**EL PASO COUNTY PLANNING AND
 COMMUNITY DEVELOPMENT
 DEPARTMENT**

STORMWATER MANAGEMENT PLAN CHECKLIST

Revised: July 2019

[illegible]

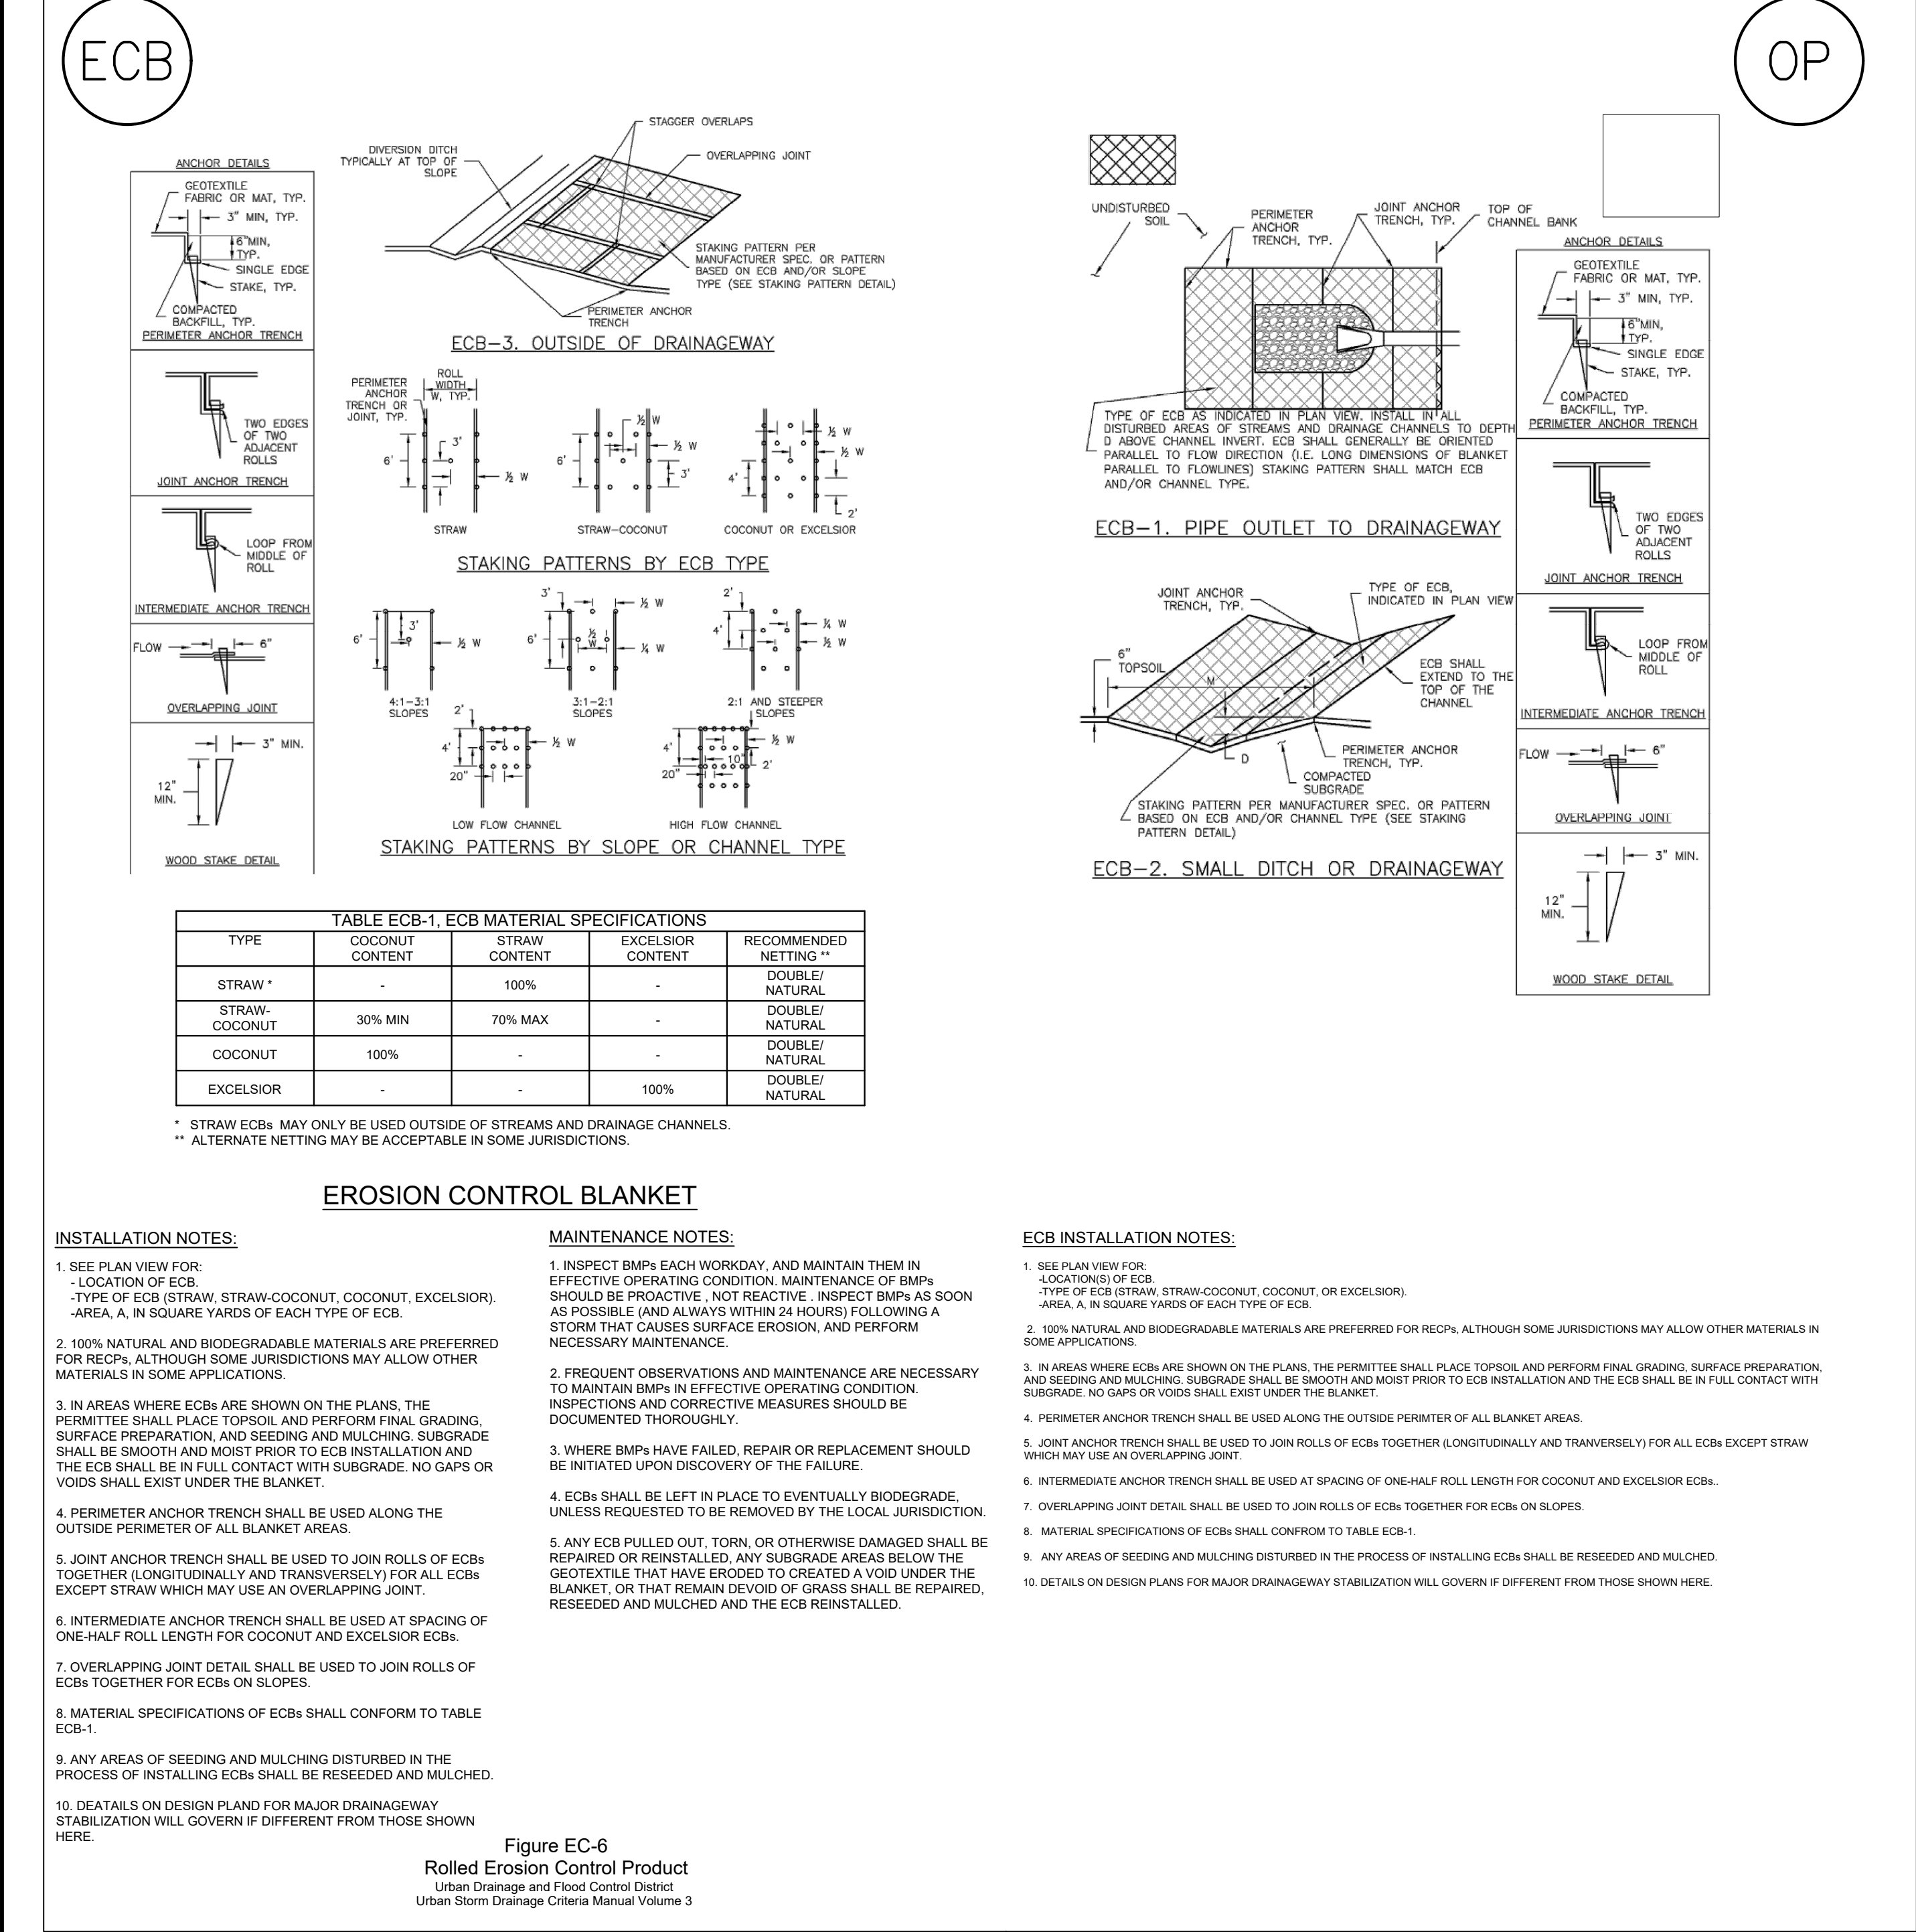
20	Technical drawing details for all control measure installation and maintenance; custom or other jurisdiction's details used must meet or exceed EPC standards Include detail for Mulching		X
21	Procedure describing how the SWMP is to be revised		X
22	Description of Final Stabilization and Long-term Stormwater Quality (describe nonstructural and structural measures to control SW pollutants after construction operations have been completed, including detention, water quality control measure etc.)		✓
23	Specification that final vegetative cover density is to be 70% of pre-disturbed levels		✓
24	Outline of permit holder inspection procedures to install, maintain, and effectively operate control measures to manage erosion and sediment		X
25	Record keeping procedures identified to include signature on inspection logs and location of SWMP records on-site See note on pg 24		X
26	If this project relies on control measures owned or operated by another entity, a documented agreement must be included in the SWMP that identifies location, installation and design specifications, and maintenance requirements and responsibility of the control measure(s).		X
